From: Paul Cann <Paul.Cann@arun.gov.uk> **On Behalf Of** Land Drainage
Sent: 02 January 2020 16:10
To: Planning.Responses <Planning.Responses@arun.gov.uk>
Subject: RE: Planning Consultation on: A/166/19/RES

APPLICATION NO: A/166/19/RES

Site Address: The Laurels Dappers Lane Angmering BN16 4EN

Description of Works: Approval of Reserved Matters following Outline consent (Reference A/74/18/OUT) relating to the layout, scale, appearance and landscaping for the erection of 9no two storey dwellings consisting of 2no two bedroom dwellings, 3no three bedroom dwellings and 4no four bedroom dwellings - This is a Departure from the Development Plan

TITLE Proposed Drainage Strategy Plan

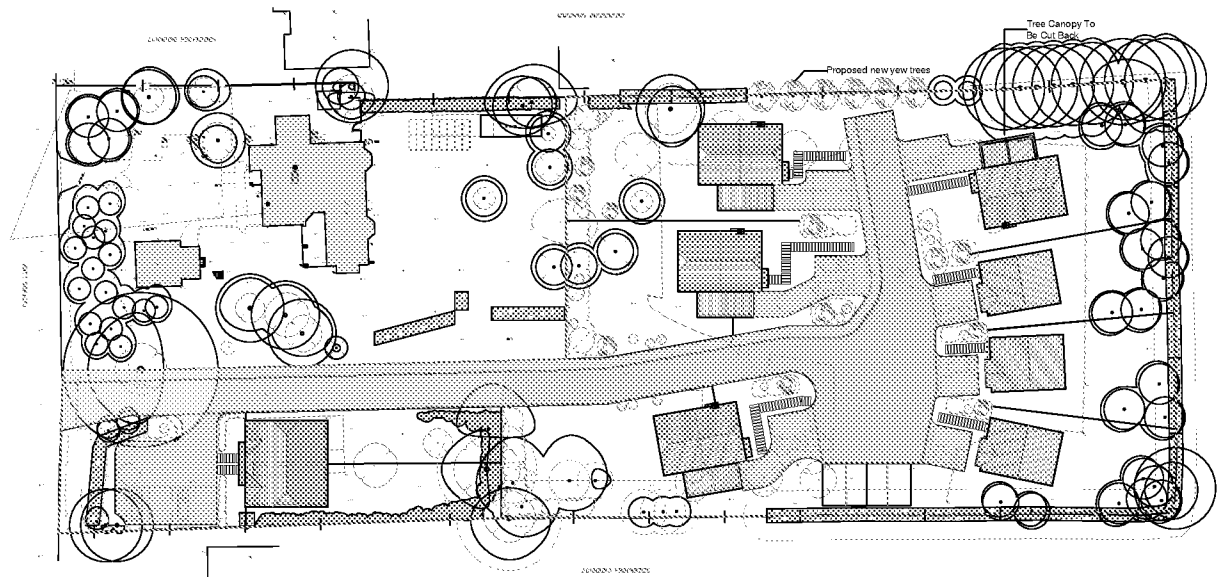
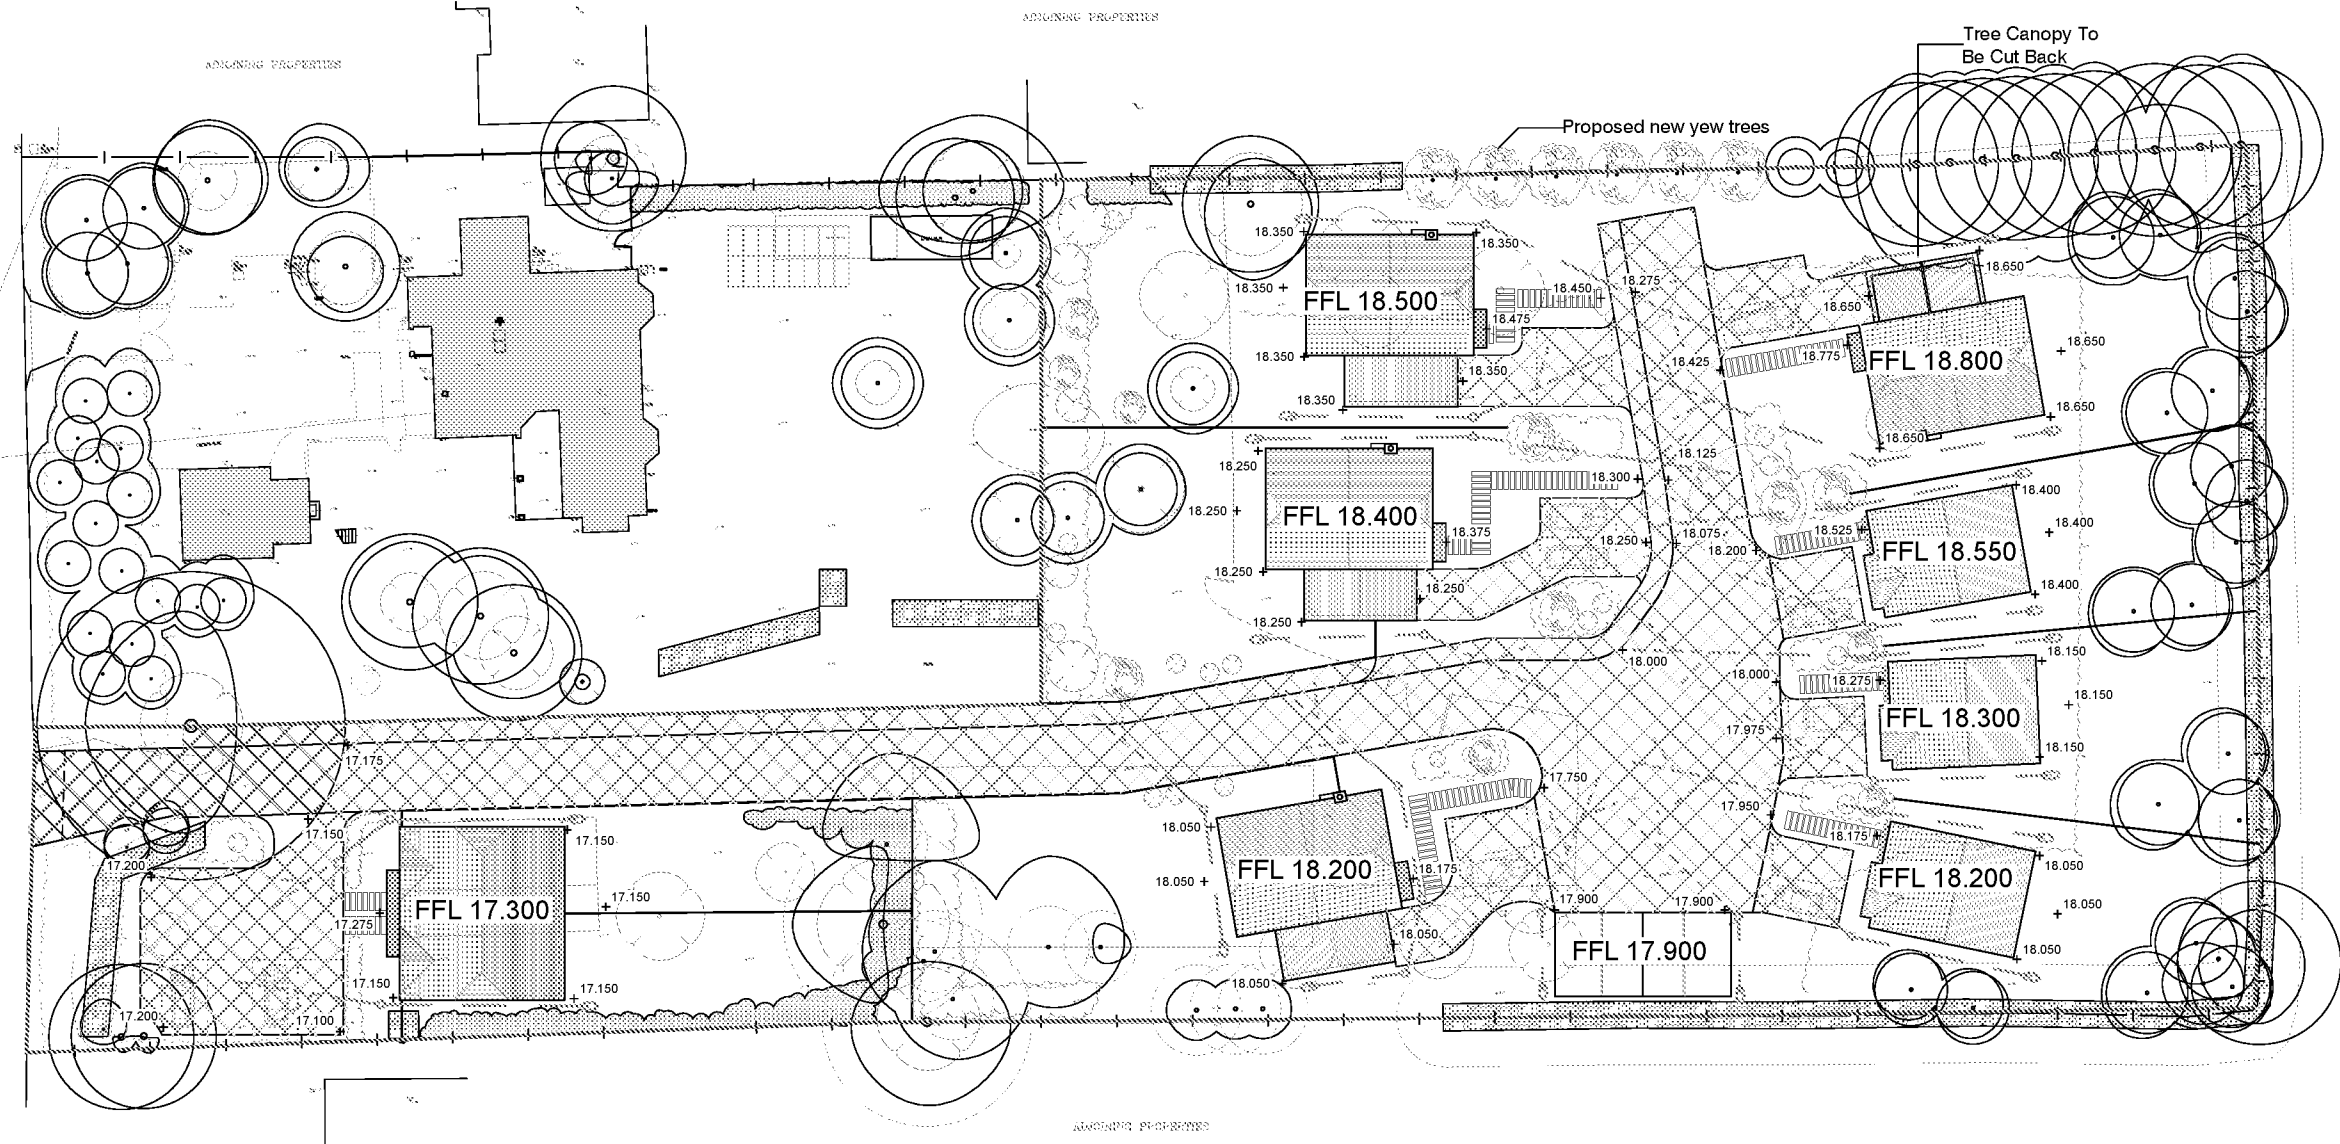
A surface water drainage scheme can be accommodated within the proposed development layout but will need some adjustments/further investigations in order to fine tune the design.

Detailed Planting Plan - Ornamental Planting The Laurels, Dapper's Lane, Angmering, West Sussex

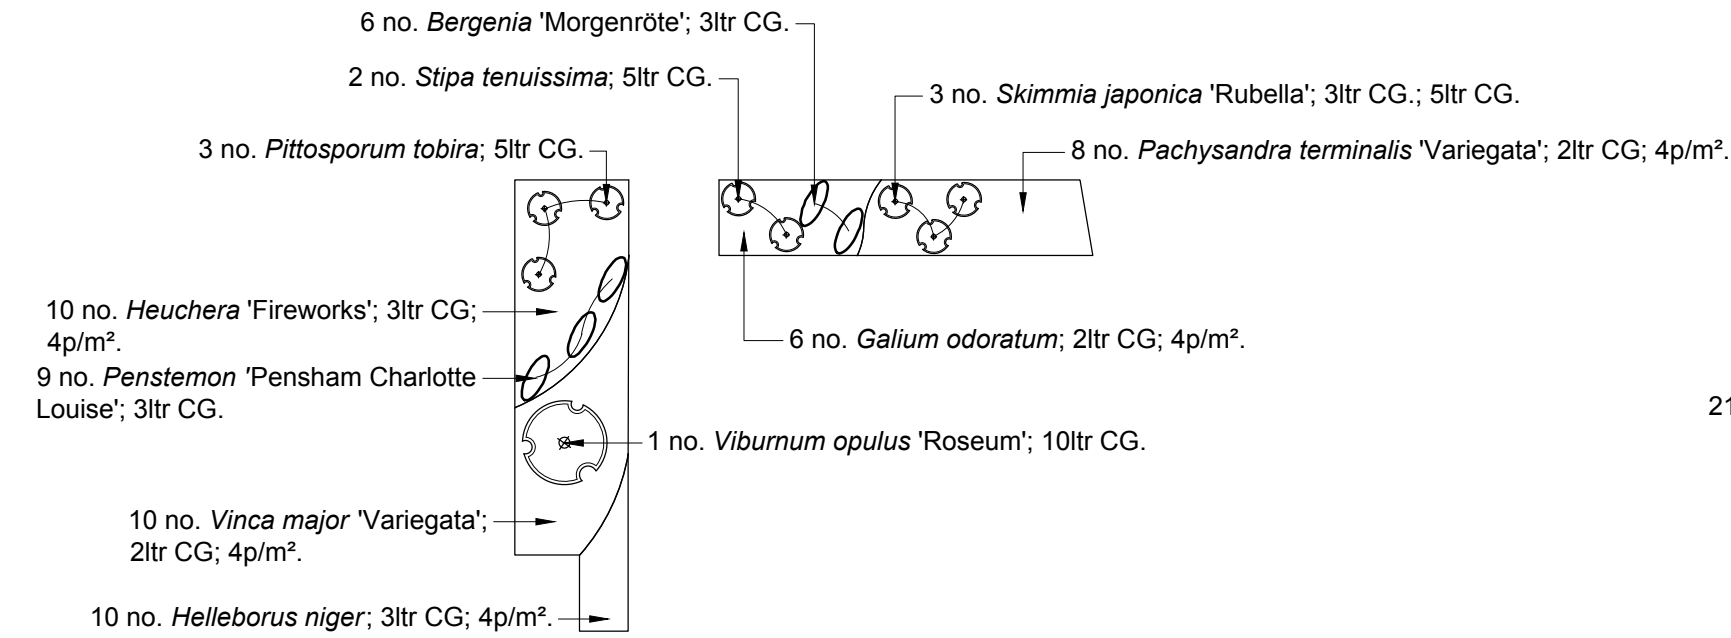
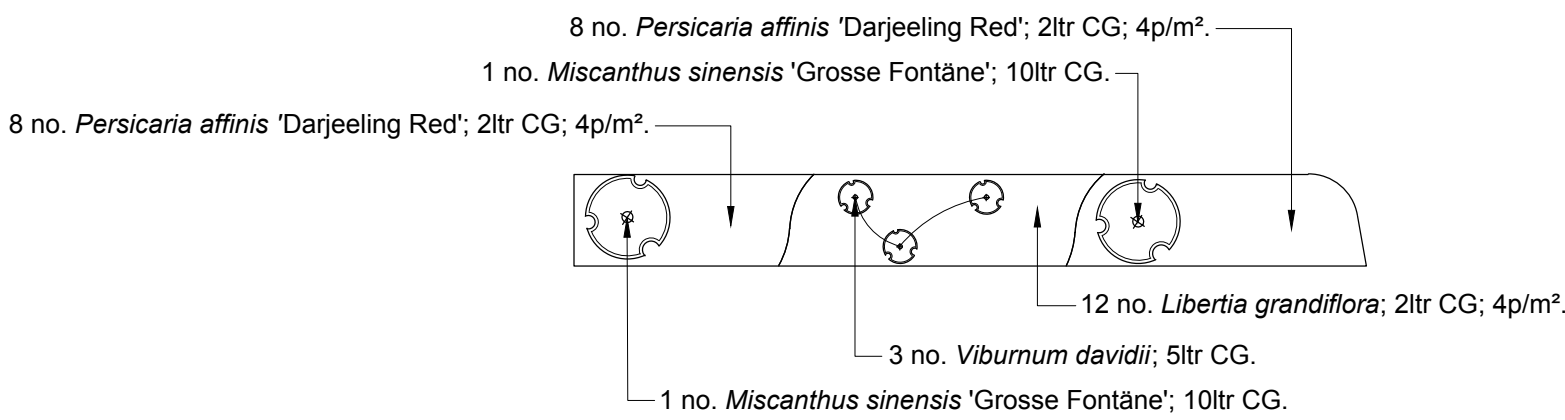
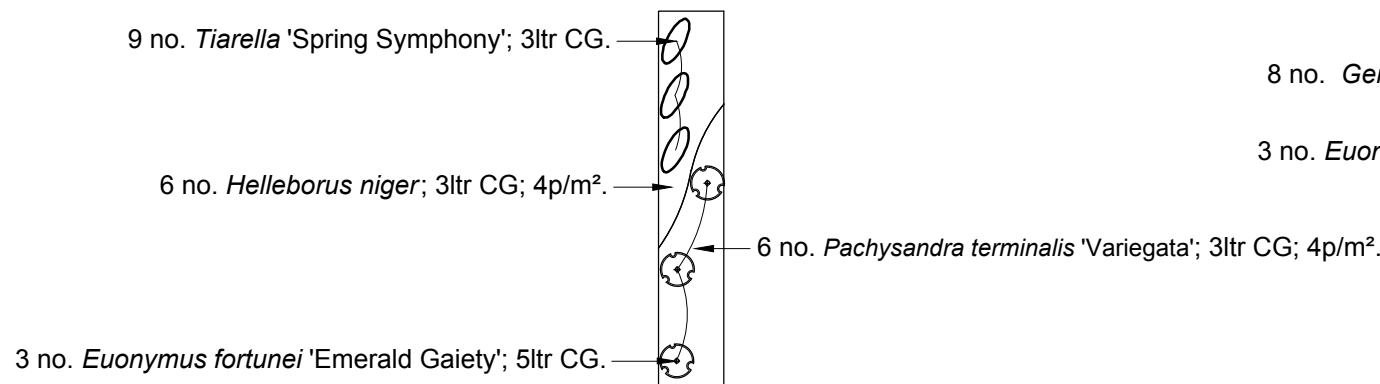
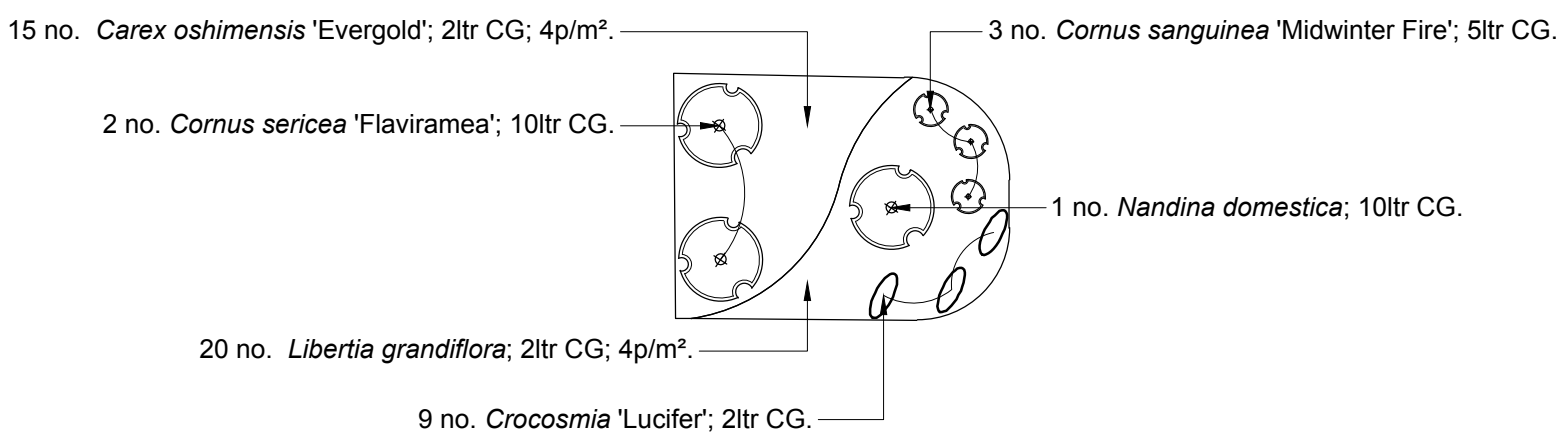
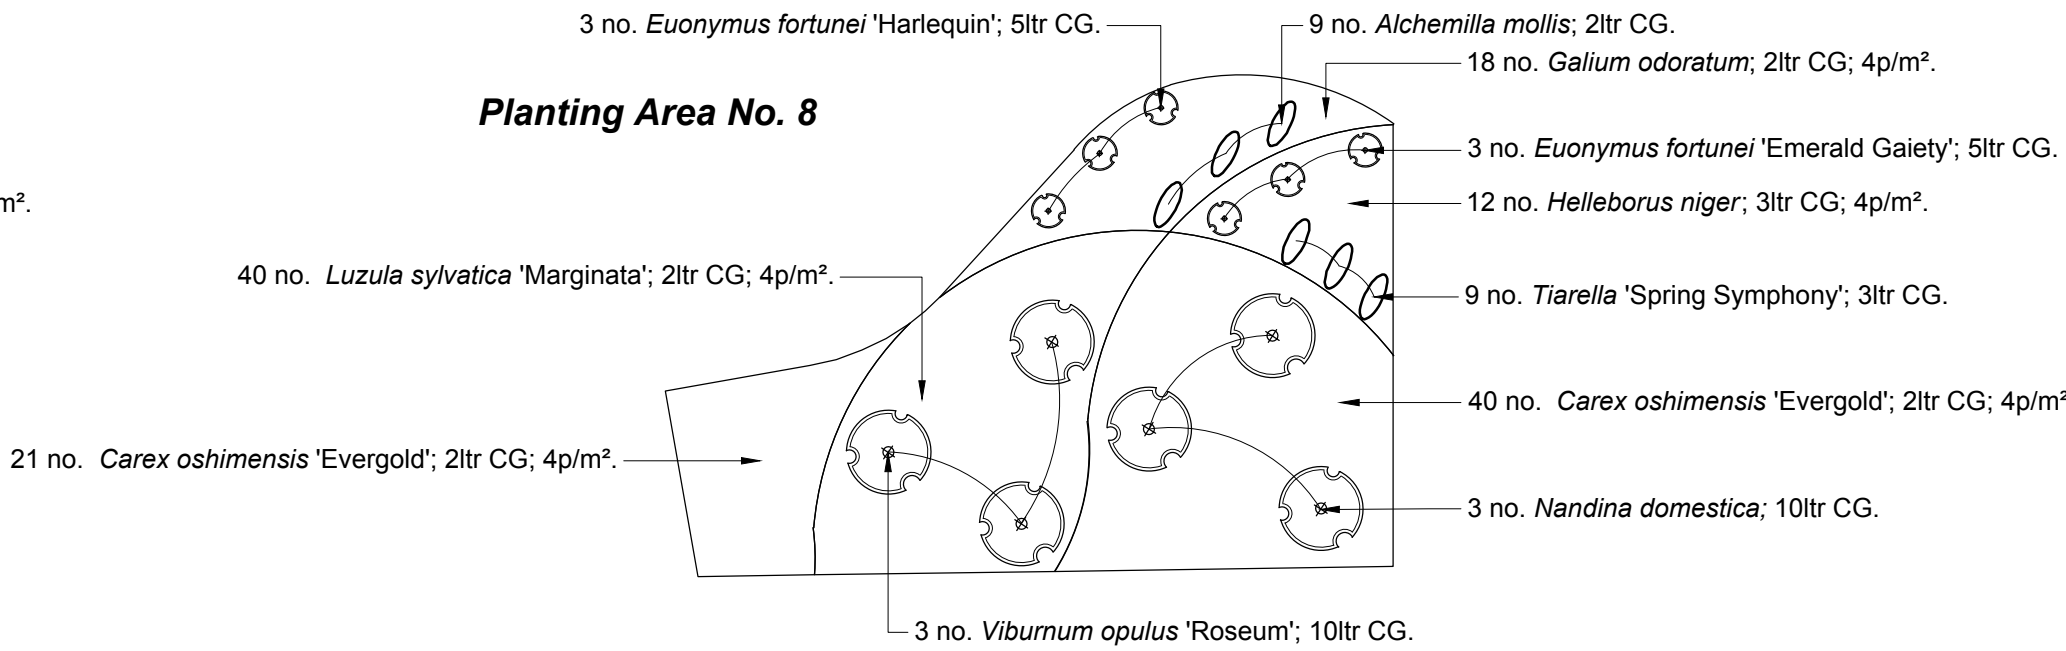
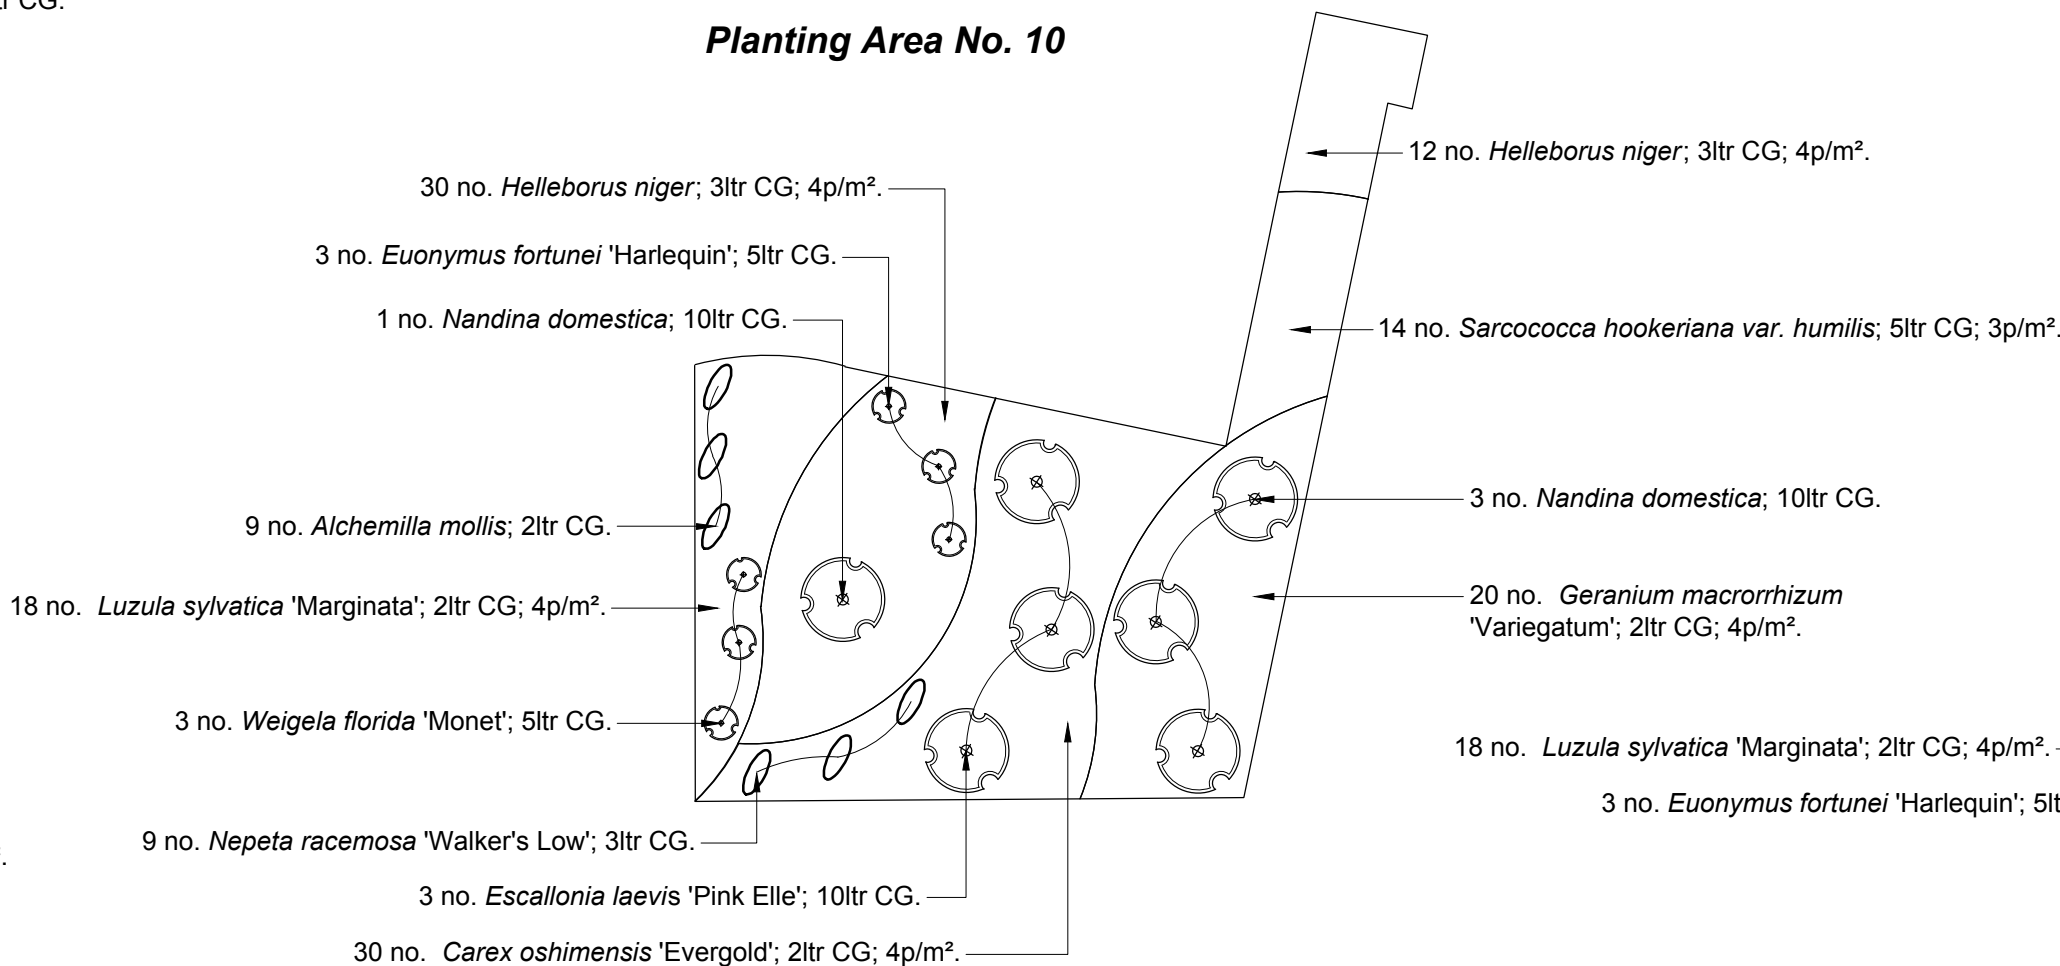
This includes matters concerning the tree planting scheme, that needs to take account of the culverted watercourse on the western boundary, ensuring no detriment to the pipeline.
